# Rezoning Transportation Analysis

Petition Number: 2021-090

## Revision Log:

Date	Description
8-20-2021	First Review (DBS)
9-23-2021	Second Review (BB)

SHEET NUMBER
RZ101

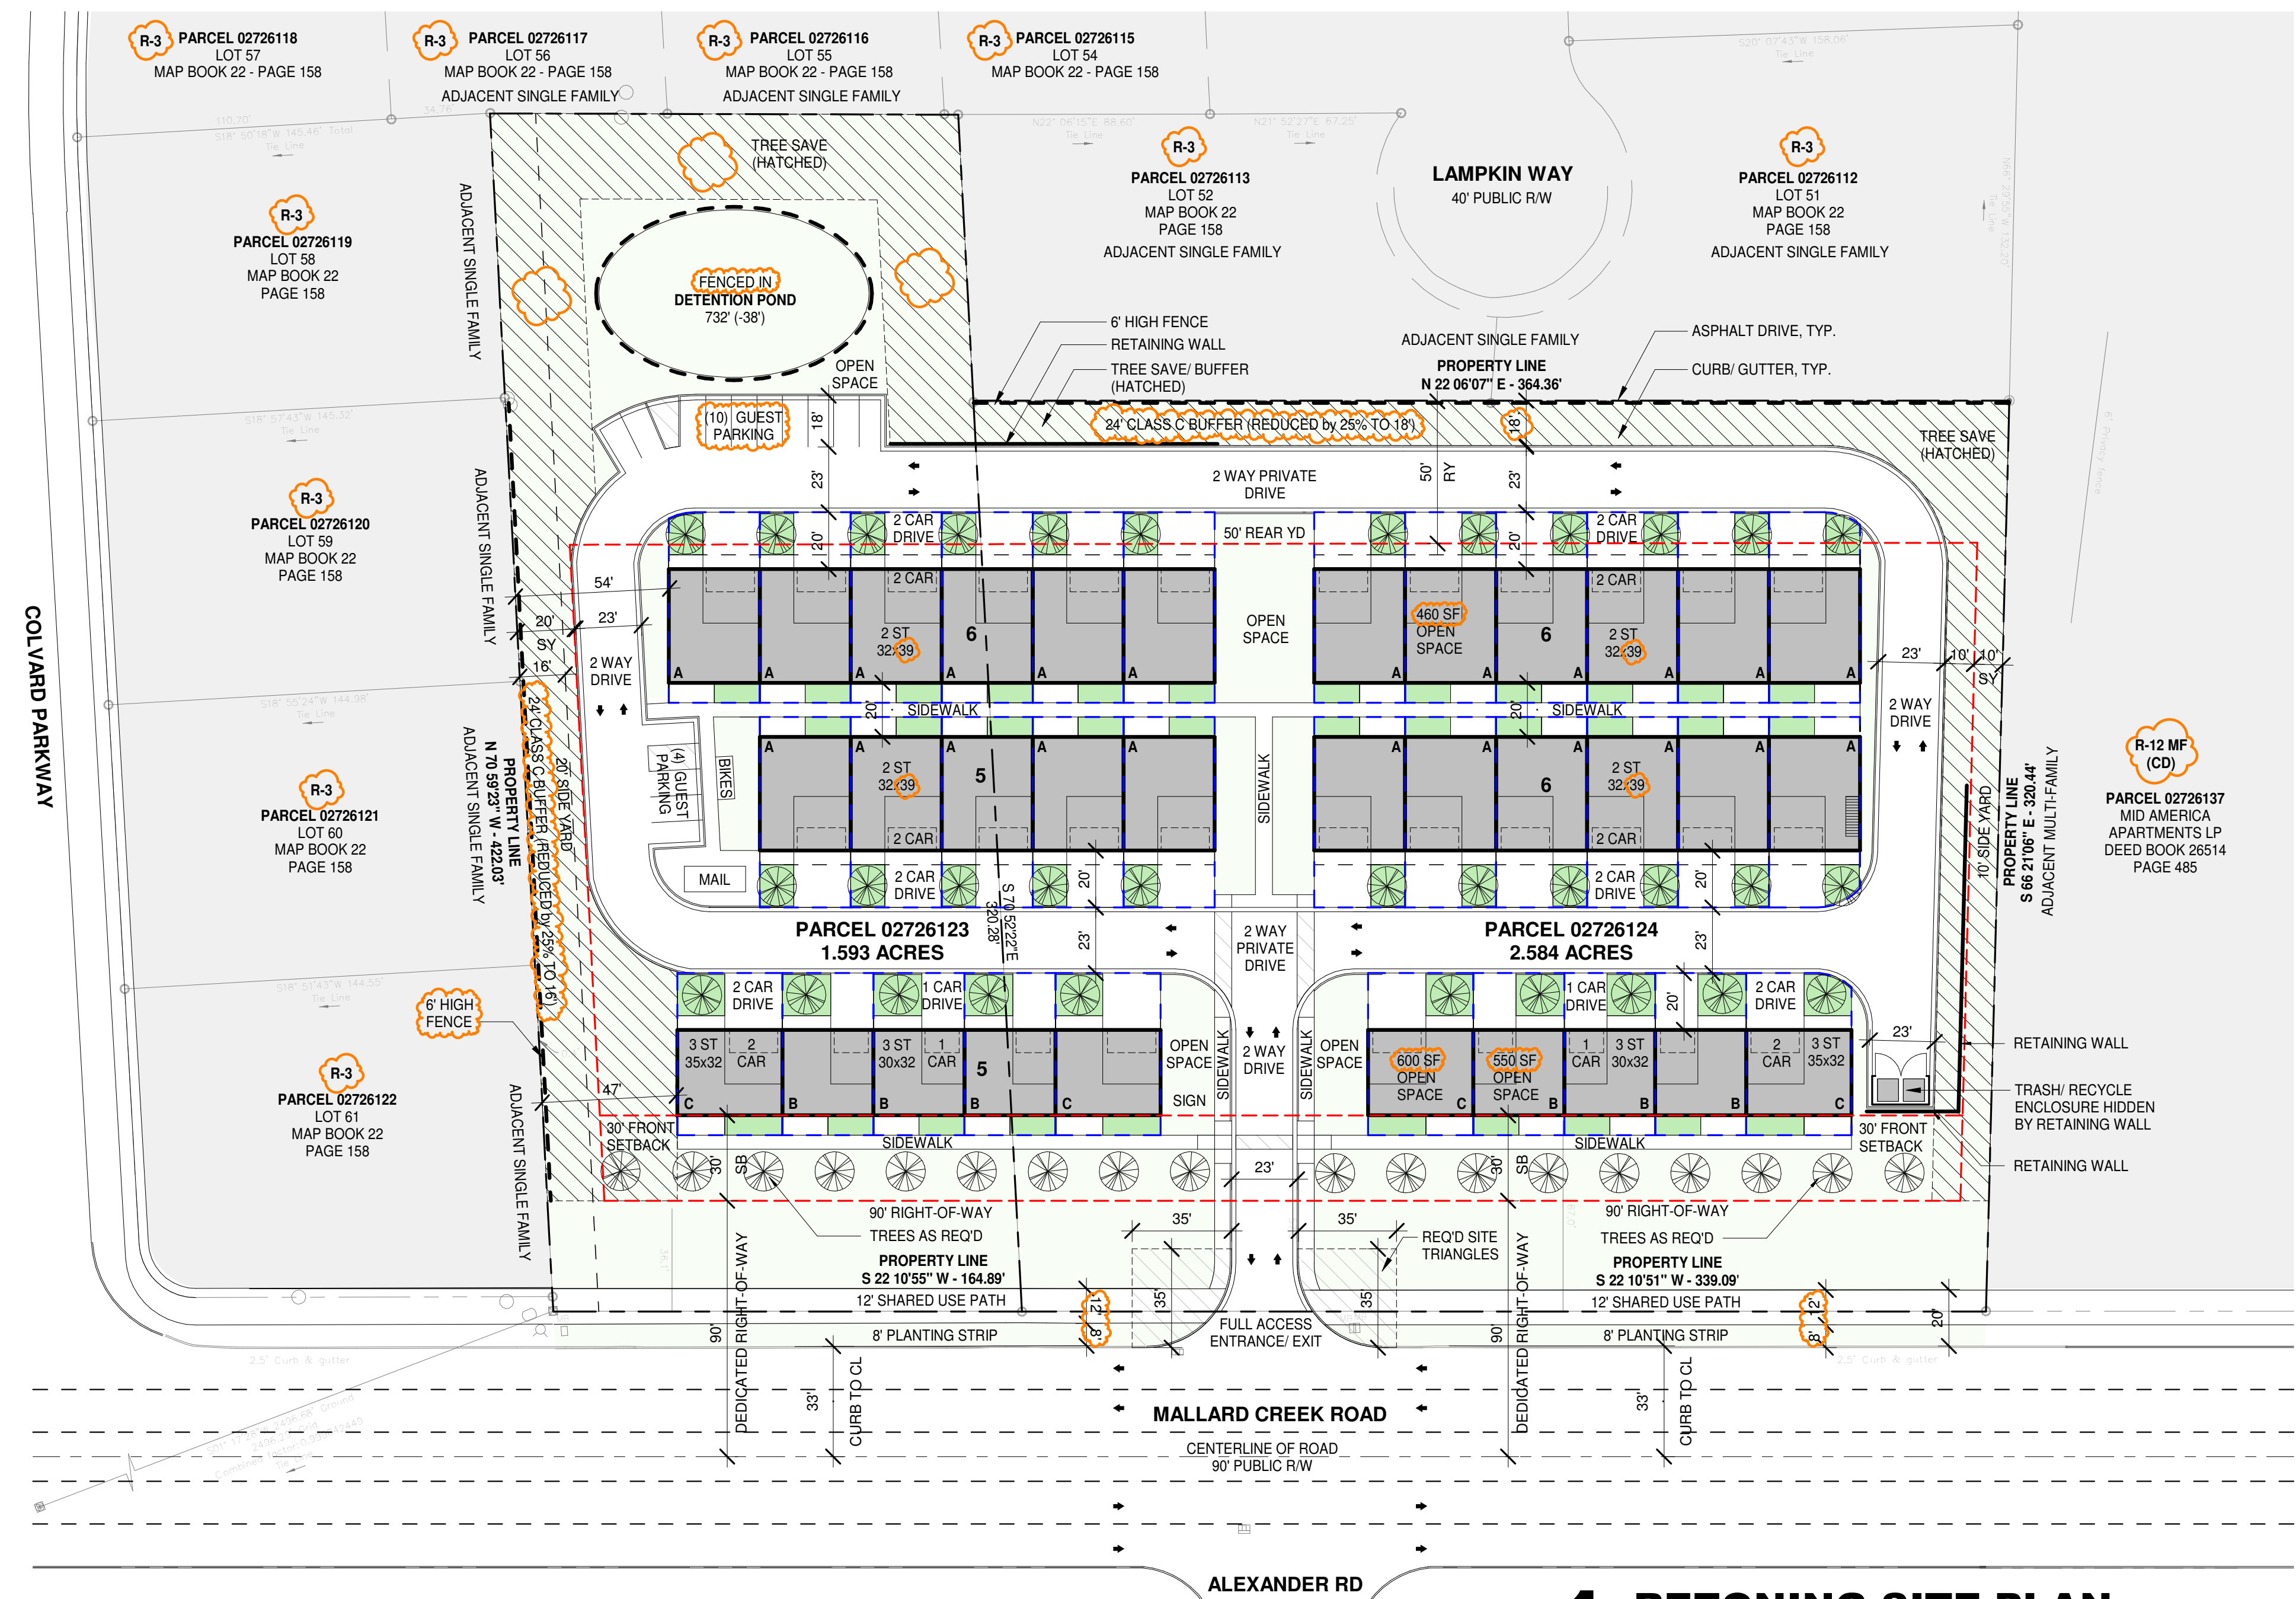
1. A Traffic Impact Study (TIS) is not necessary for the complete review of this petition due to the site generating less than 2,500 daily trips. If during the permitting process the site generates more than 2,500 daily trips, a traffic study will be required.
2. **Outstanding Comment (site plan dated: 9-1-2021):** The site plan reflects dedicating 90' of right-of-way from the road centerline. Based on the street classification and street/streetscape elements, this right-of-way width is not needed and can be reduced to the distance from the road centerline to 2' behind the back of the shared-use path. Revise site plan to label and dimension the right-of-way from the road centerline based on the above.

Revise site plan to locate the planting strip adjacent to the back of curb and the shared-use path between the planting strip and the site.

3. **Outstanding Comment (site plan dated: 9-1-2021):** A site plan note(s) specifying dedication and fee simple conveyance of all rights-of-way to the City before the site's first building certificate of occupancy is issued is needed. As noted above, CDOT requests rights-of-way be set at 2 feet behind the back of shared-use path where feasible.
4. **Outstanding Comment (site plan dated: 9-1-2021):** All public roadway improvements will be subject to the standards and criteria of CDOT and NCDOT, as applicable, to the roadway improvements within their respective road system authority. It is understood that such improvements may be undertaken by the Petitioner on its own or in conjunction with other development or roadway projects taking place within the broad north central Mecklenburg area, by way of a private/public partnership effort or other public sector project support.
